# **Land East of Junction 11 of the M40, Banbury**

## *Transport Assessment Addendum*

26<sup>th</sup> October 2022  
SJT/RT/23457-06f Transport Assessment Addendum

- 1.5 It is within this context that a Transport Assessment (TA) was prepared which supported a planning application for this development. Oxfordshire County Council (OCC) have commented on this application (ref: 22/01488/OUT) which can be seen in **Appendix B**. This includes a list of transport improvements.

FIGURE 5: ILLUSTRATIVE SITE LAYOUT

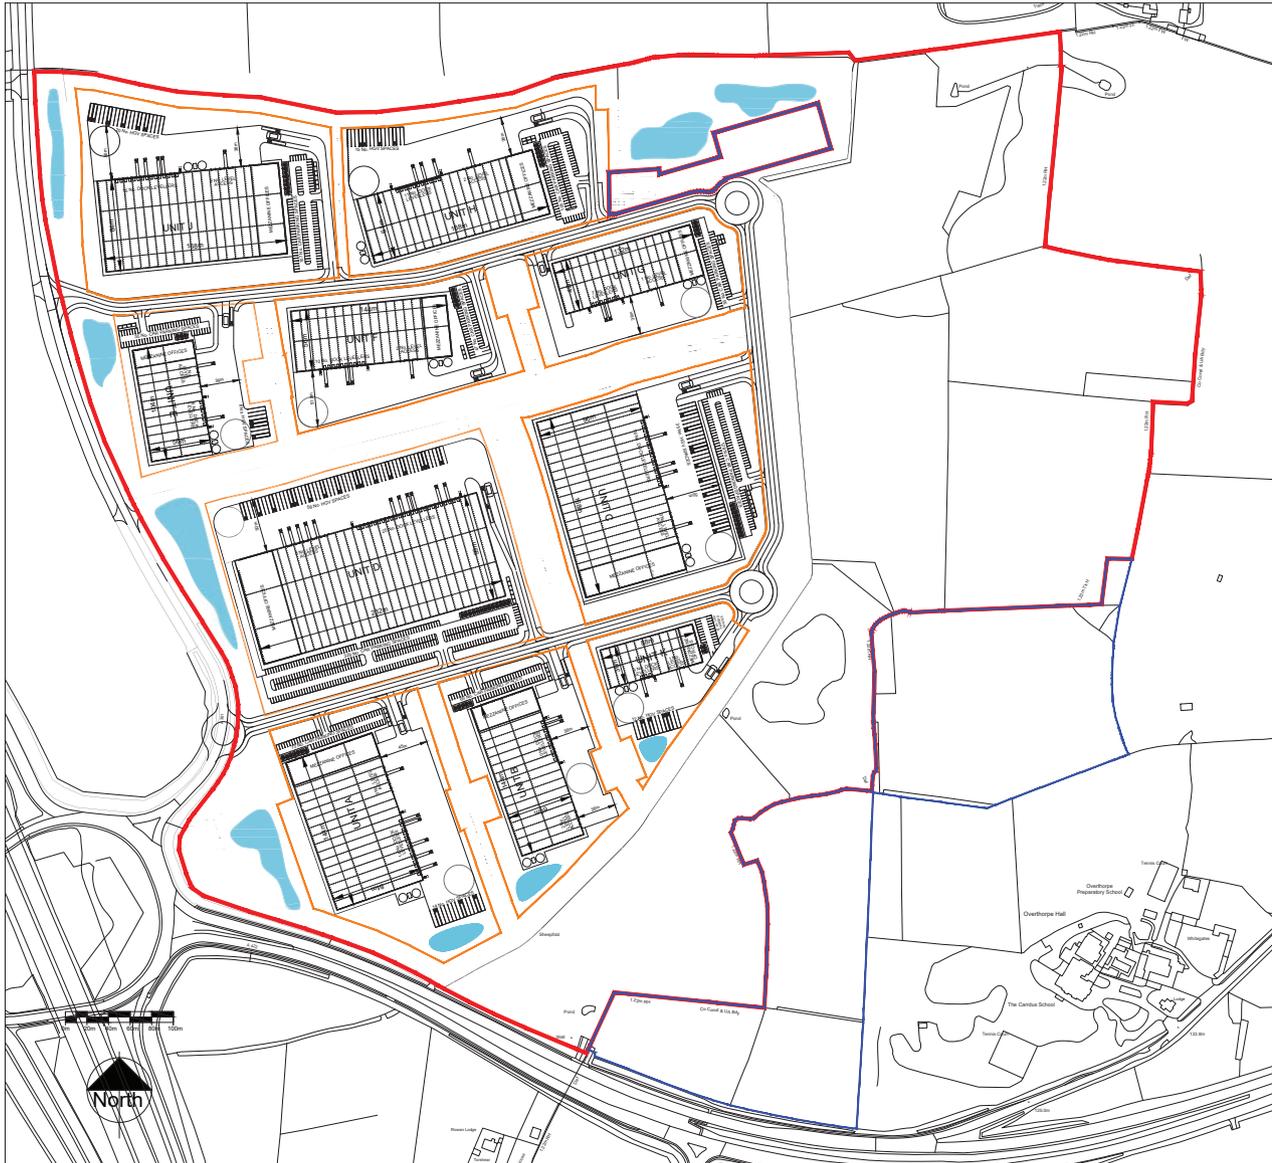
*Final layout of the development will be determined at the Reserved Matters stage. However, the design shown in the Illustrative Site Layout drawing (no. 05001 Rev. P8) is unlikely to be acceptable.*

*The internal street layout is simple, with each industrial unit being accessed directly from the distributor road which terminates at the primary and secondary access points. All footways must be 2.0m wide and car parking spaces at least 5.0m x 2.5m.*

*The Site Layout shows the road leading from the primary access to be a straight length of 460m, and directly serving only three of the ten Units. Many vehicles will therefore be travelling the full length, so are likely to do so at speed if not calmed somehow. Deviations or features are typically placed at a maximum spacing of 70m to reduce speeds. All three links of the distributor road have excessive straight lengths so a major adjustment to the road layout will be necessary before it may be considered acceptable.*

*An internal network of pedestrian and cycle paths should be incorporated to keep active travellers clear of the road network and to encourage these modes of transport. The network should emerge on the A361 at the location of the signalised crossing (to be provided by this development).*

- 7.1 The internal access roads will not be adopted, and residential design principles are unlikely to be appropriate on a commercial site that must accommodate large commercial vehicles particularly taking into account that the Government is actively considering allowing larger commercial vehicles on the road network up to 25m. The requirements for the internal layout of the site can be achieved through a condition if demonstrably necessary, but as identified by OCC the site layout at present is illustrative as the application is in outline.

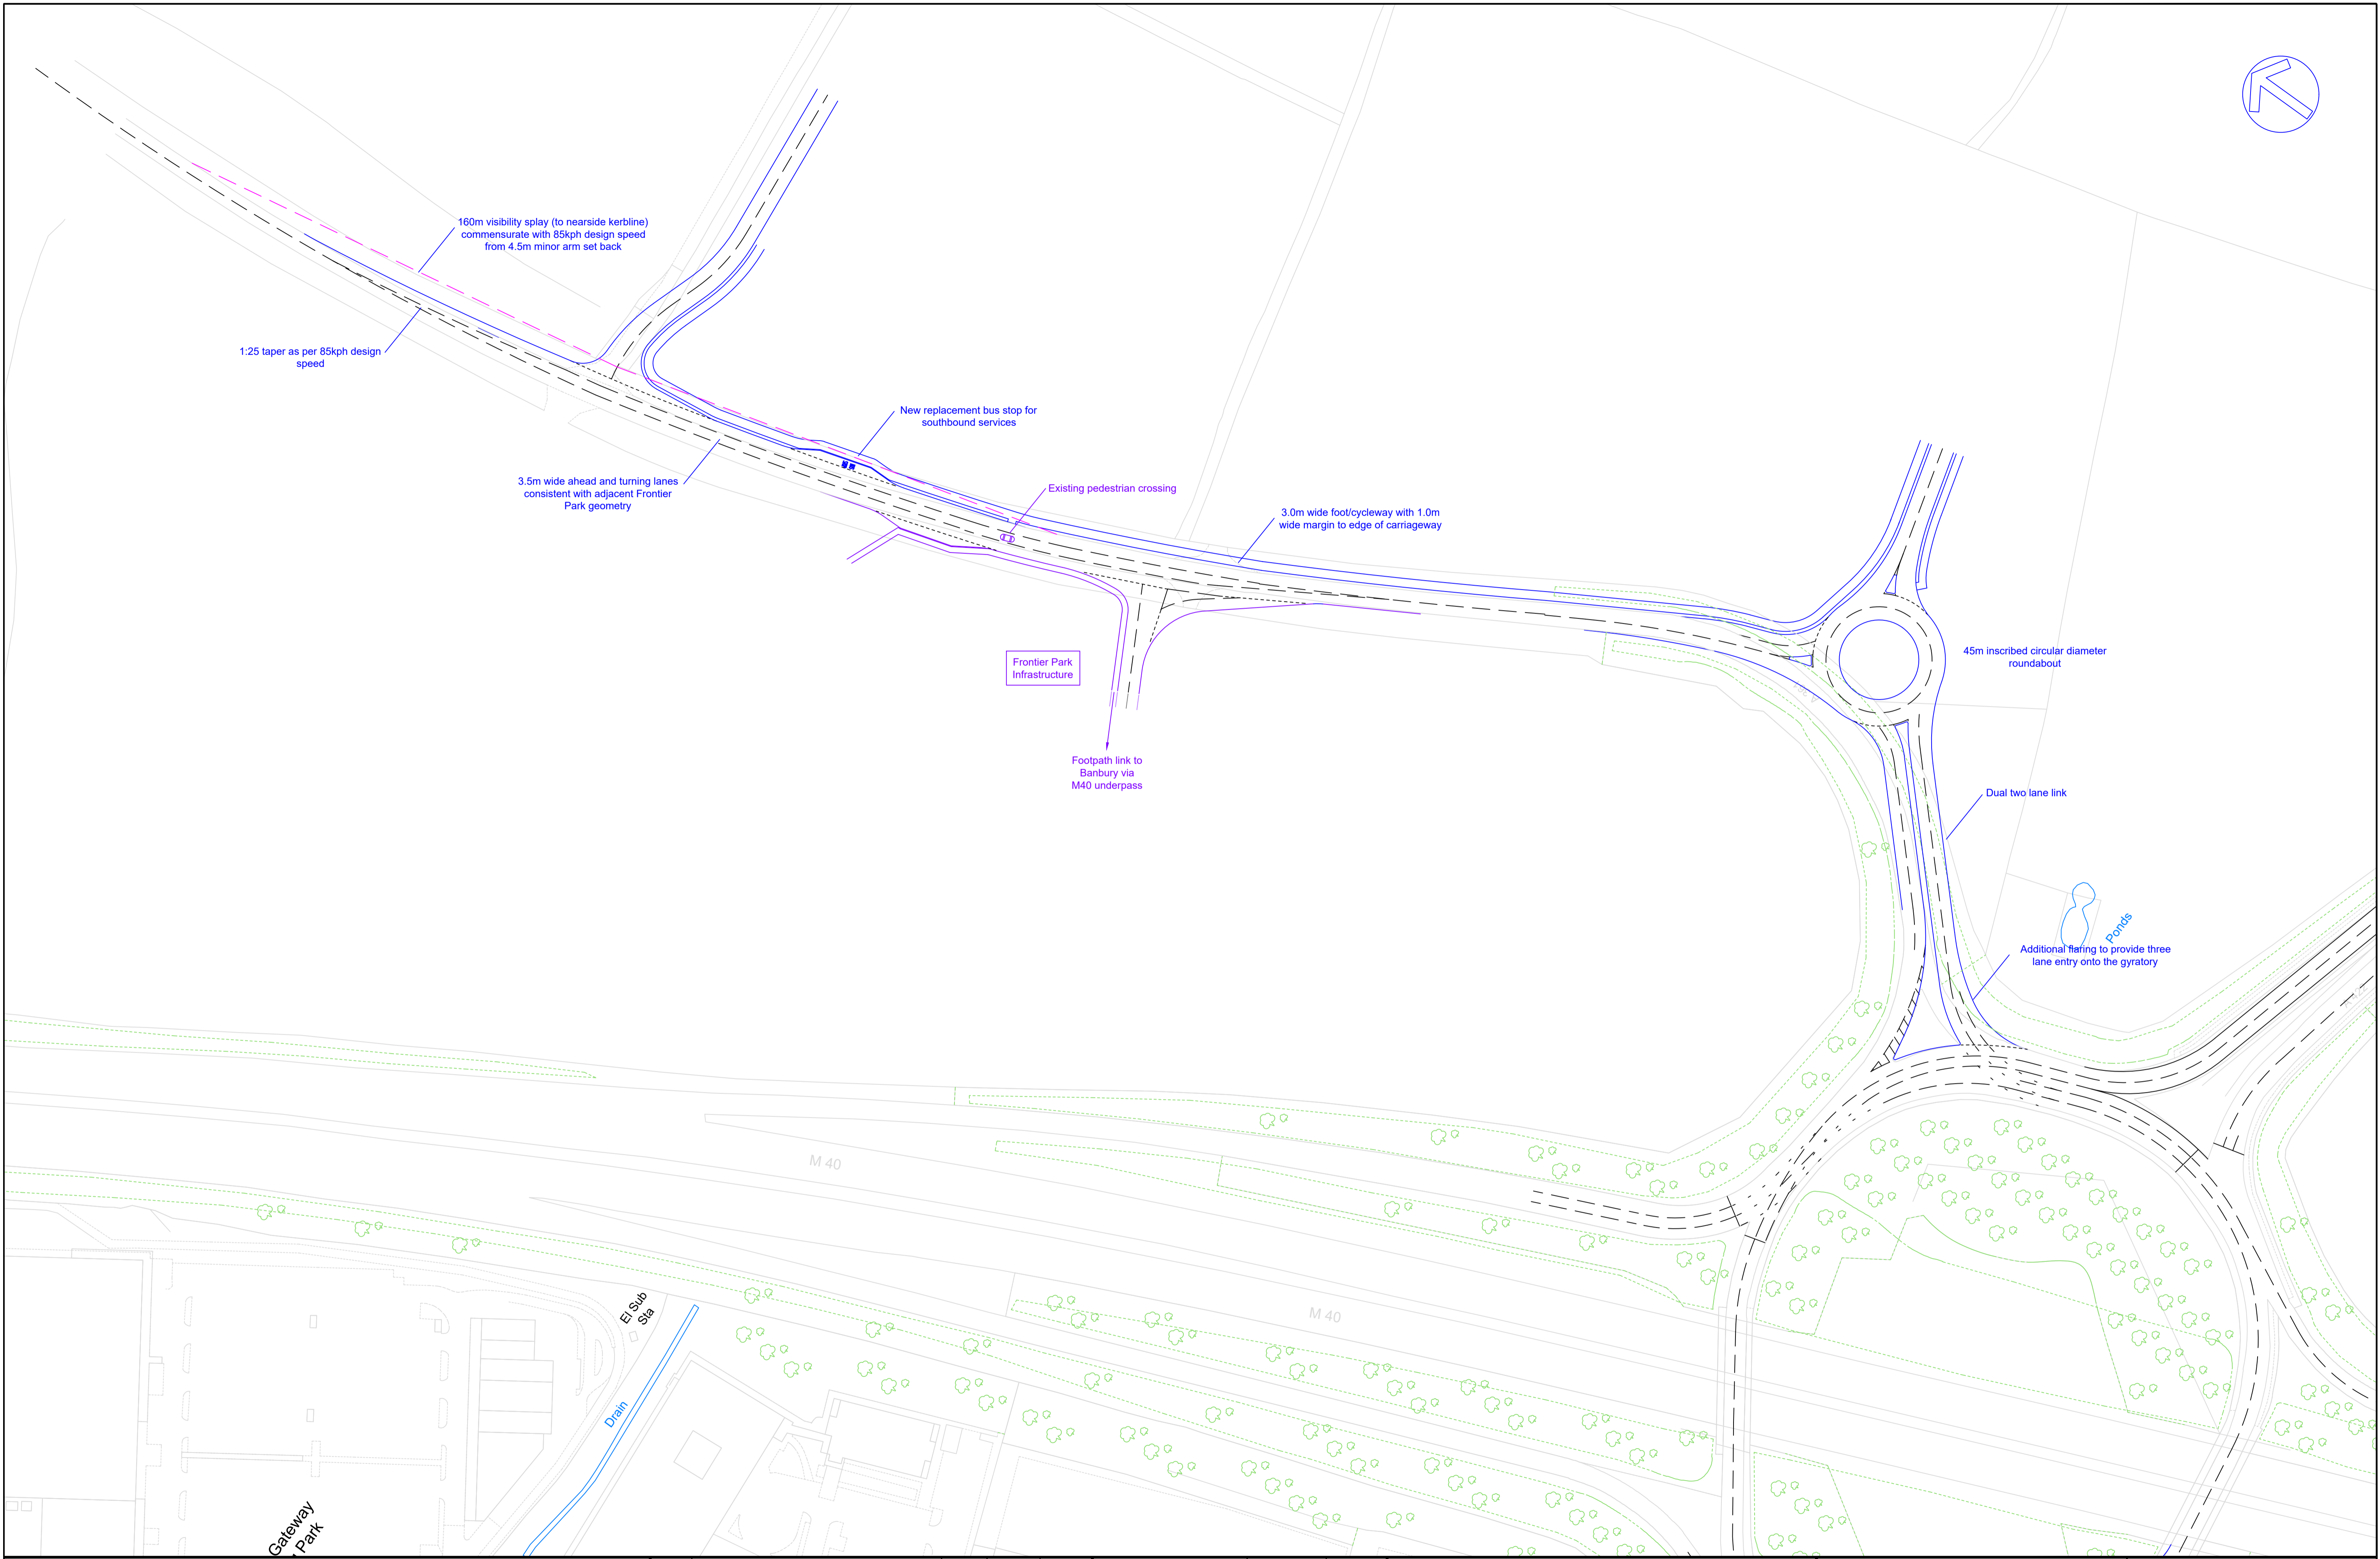
*The primary access would be a three-arm roundabout located just a little over 100m from the A361 exit on to the Junction 11 roundabout. This proximity is likely to cause occasional severe congestion issues and is a reason for objection. See further discussion below under Traffic Impact. It has not been demonstrated that there is sufficient distance to accommodate the necessary direction signage.*

*As the walking route would entail crossing the busy A361, a signalised crossing will be required, on the desire line between Frontier Park and the site access, to ensure pedestrian safety along the only available route.*

- 4.1 The site access junction has been located to remove a tight horizontal curve through which forward visibility below desirable minimum for the posted speed limit is not achievable within highway land. As set out below queue lengths without the development are forecast to increase significantly in the future with interaction with the substandard bend more likely in the future. Removal of the bend and replacement with a roundabout will make the legibility of the arrangement and queue patterns materially better which is positive from a road safety perspective.

- 4.2 The A361 South entry onto the proposed roundabout has a maximum unopposed capacity of (intercept) of 2,267 PCU/hr. The forecast future year demand (base + committed development + development demands) is slightly more than 1,000 PCU/hr. The maximum effective exit flow from M40 Junction 11 onto A361 will be circa 1,500 PCU/hr i.e., the critical flow at the upstream node where all the flow from northern motorway overbridge is routing to the A361 exit (this is unlikely to happen). Even accounting for unequal lane usage, A361 ahead traffic will use the nearside lane only, the site access roundabout would not act as a bottleneck in day-to-day operation. This is demonstrated in the LINSIG and ARCADY modelling and will be further confirmed through VISSIM runs.

- 4.3 With respect to signage, there will in the future still be a single exit lane from the motorway junction gyratory. It is unlikely that the site itself warrant explicit signing from the downstream junction. Traffic to the site will in effect bifurcate from the ahead traffic into effectively a dedicated lane to the development site. Road markings would suffice however directional signage could be provided in the nearside verge at the decision point.

- 4.4 The primary access plans can be seen in **Drawing 23457-06a-01-GA** with the tracking shown in **Drawing 23457-06a-03-TRK**.

- 5.4 A signalised crossing can be provided as part of the proposed development.
